86 Ancton Way - M/20/26/PL

86 Ancton Way Drawing 001 - SITE PLANS LOCATION PLANS etc Revision PL4.pdf;

Could the attached please be uploaded as a substitute for the current 'LOCATION PLAN, EXISTING AND PROPOSED SITE PLANS, EXISTING ELEVATIONS 001 REVPL3'?

SITE PLAN - PROPOSED

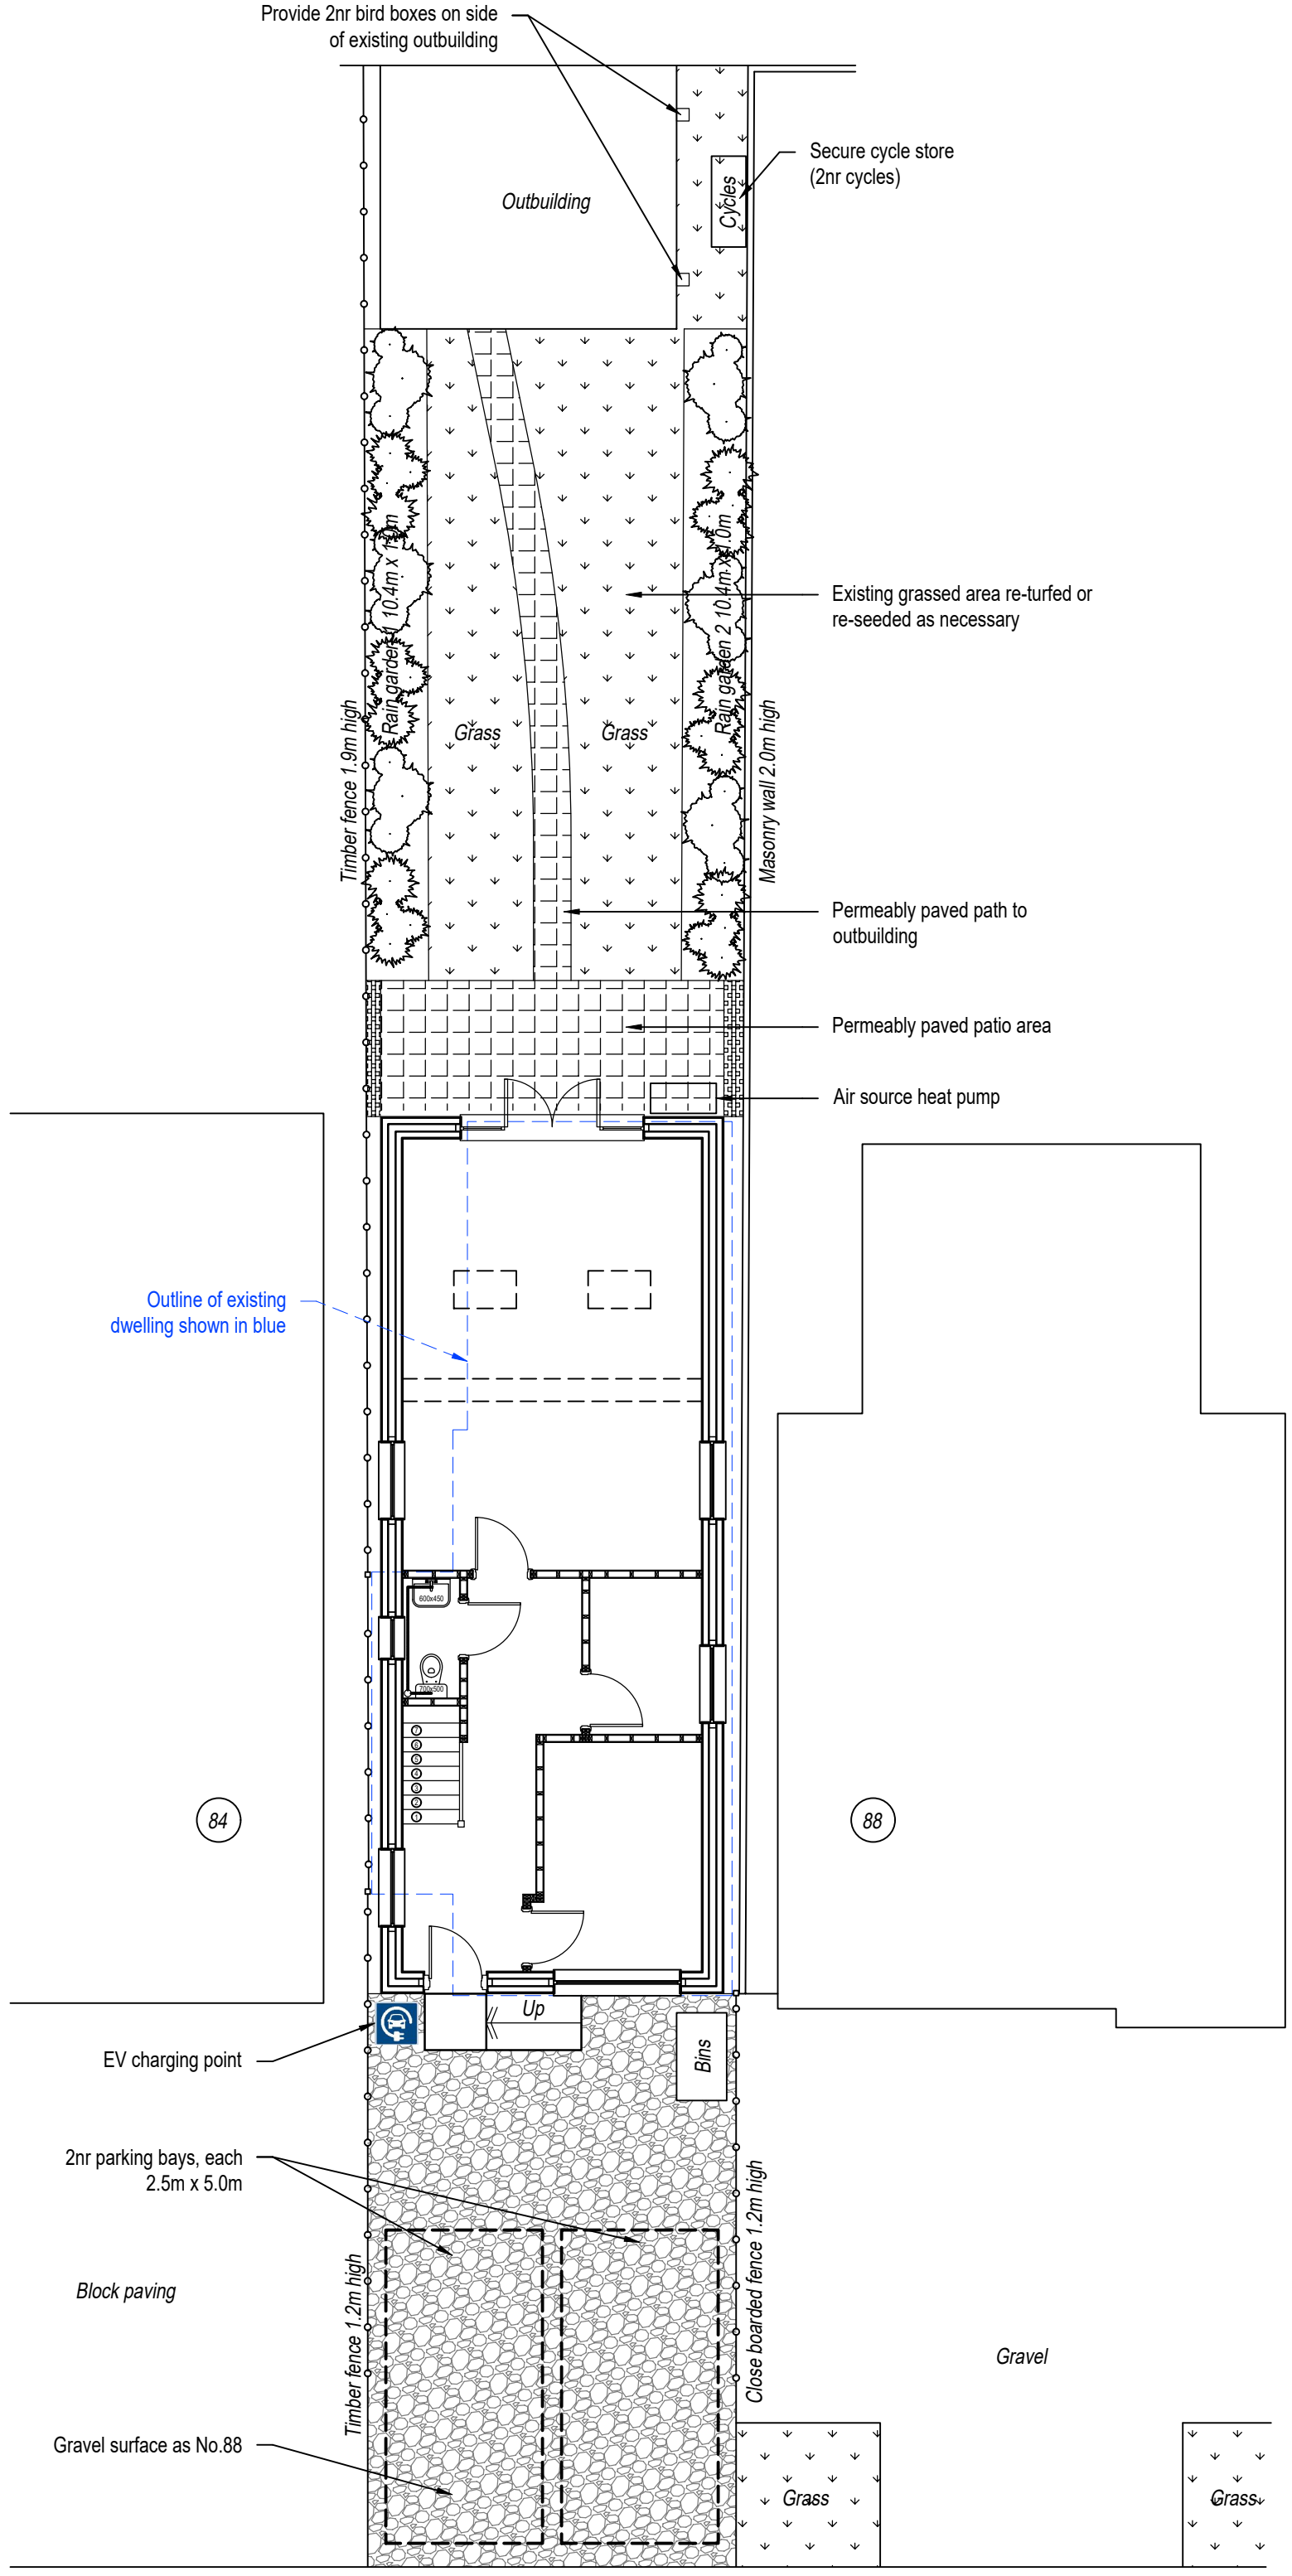
Separately to this, I mentioned in the report for the last application, that the cycle shelter in driveway may be unnecessary clutter, alongside the bin store, within a relatively tight parking area. I also note that it would appear to block/obstruct access to the proposed EV charging point. We would be satisfied that the cycle storage be provided in the rear garden in this context. If you agree with my view and want to relocate the cycle store to somewhere suitable within the rear garden, there are two ways we can deal with this. One would be to simply amend the plans accordingly, the other would be that I word the approved plans condition in such a way that says perhaps, 'notwithstanding the proposed location of the cycle store', and a condition be attached to secure finalised details of its proposed location (subject to approval).

Thanks for the email. I have relocated the cycle store to the rear garden and have amended the plan to suit. Revised drawing attached.
